TOWN AND COUNTRY PLANNING ACT 1990

OUTLINE

Reference:	H04-1034-15	Date of Decision:	5th February 2016
Applicant:	Mr M Bond 39 High Street Donington Spalding Lincs PE11 4TA		
Location:	Rear: 39 High Street Donington Spalding Lincs		
Description:	Outline application for detached bungalow

Site Block Plan
1 : 200

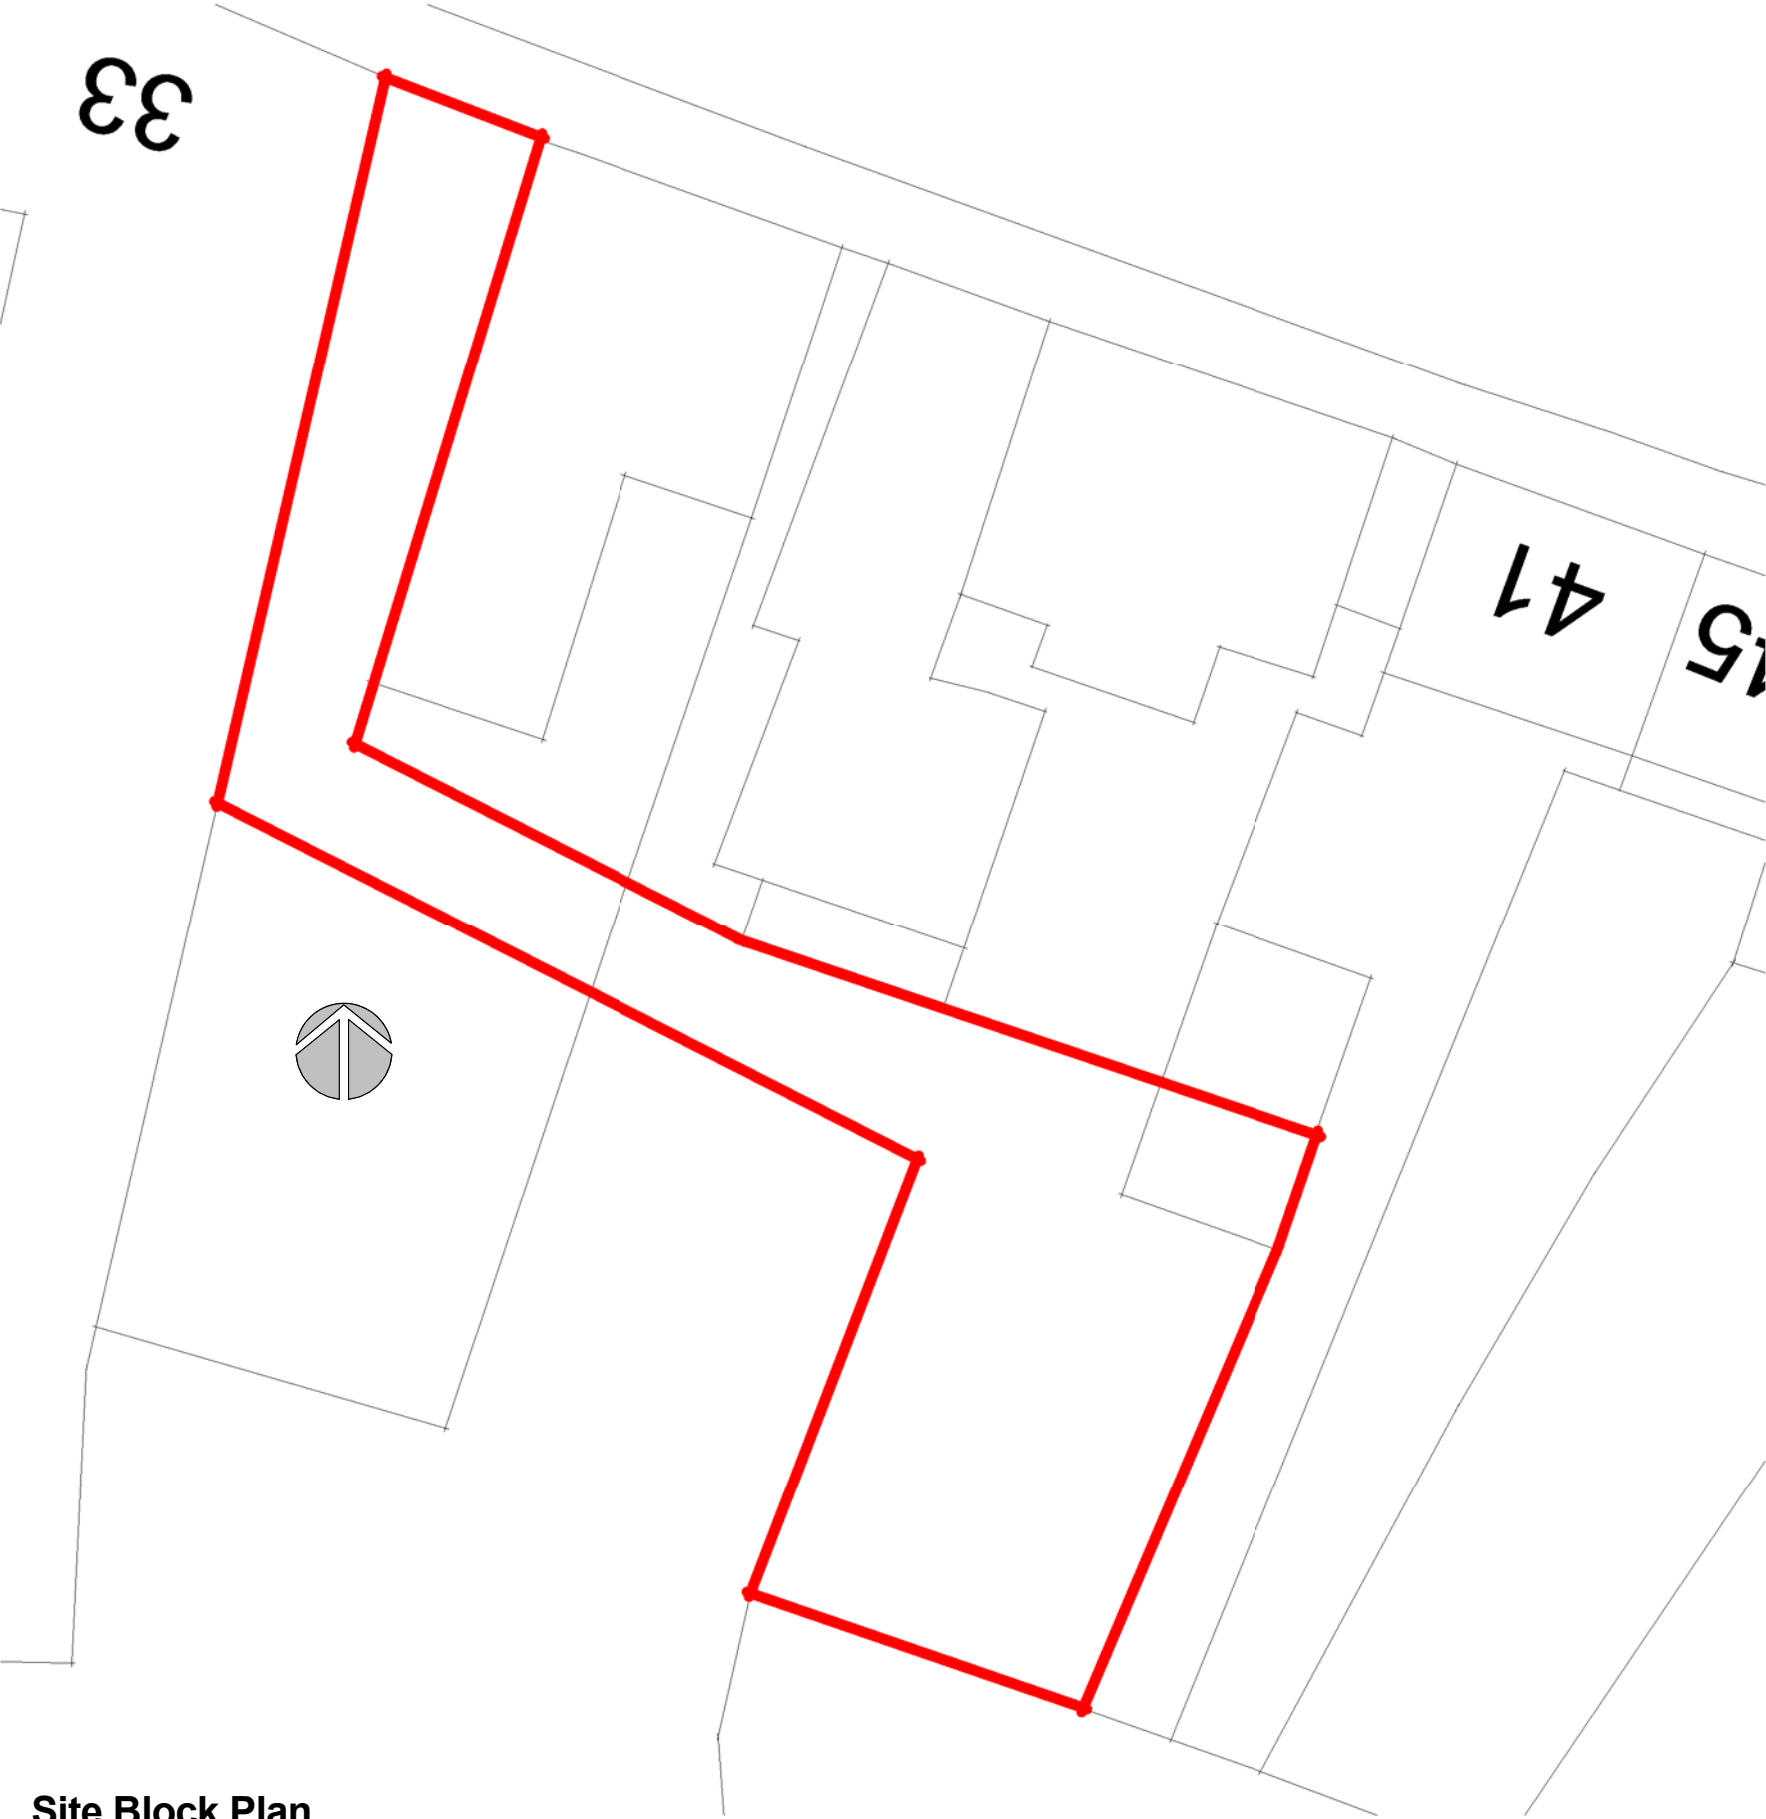
- 1 The proposed development would result in a backland development which would constitute a cramped and incongruous form of development at odds with the existing form and character of the surrounding area, which forms part of the Donington Conservation Area. This is by virtue of its plot size, location and relationship with neighbouring properties. Moreover, by virtue of its backland location, it would result in an adverse impact on any future occupiers due to its poor outlook onto the rear of other dwellings, fences and foliage which would likely create an unacceptable standard of accommodation. As such, the proposal is considered contrary to Policies SG14 and SG17 of the South Holland Local Plan, 2006, Paragraphs 17, 53, 58 and Sections 6 and 7 of the National Planning Policy Framework, 2012. These policies indicate that new development should:

- 2 The existing access point onto the High Street is considered unsuitable to accommodate any additional vehicle movements that might occur, either now or in the future, as a result of the proposed development. The proposal has not considered pedestrian safety from and to the proposed development from vehicles already using this access way, especially as there is no pre-existing pedestrian pathway. In addition, the existing road width and right angled bend would also be unable to accommodate service vehicles for the site, leading to a potential increase in the incidence of vehicles waiting on the highway which may impact highway safety. The existing access road is not wide enough to be used as a shared vehicular access for a residential dwelling as the bend is too narrow should vehicles meet, coupled with insufficient views around the bend to see oncoming vehicles. The proposal is therefore contrary to Policy SG15 of the South Holland Local Plan, 2006. This policy states that proposals for development shall provide safe and convenient access to and within the site for motor vehicles and pedestrians to accommodate the potential increase in movement generated by the proposal.
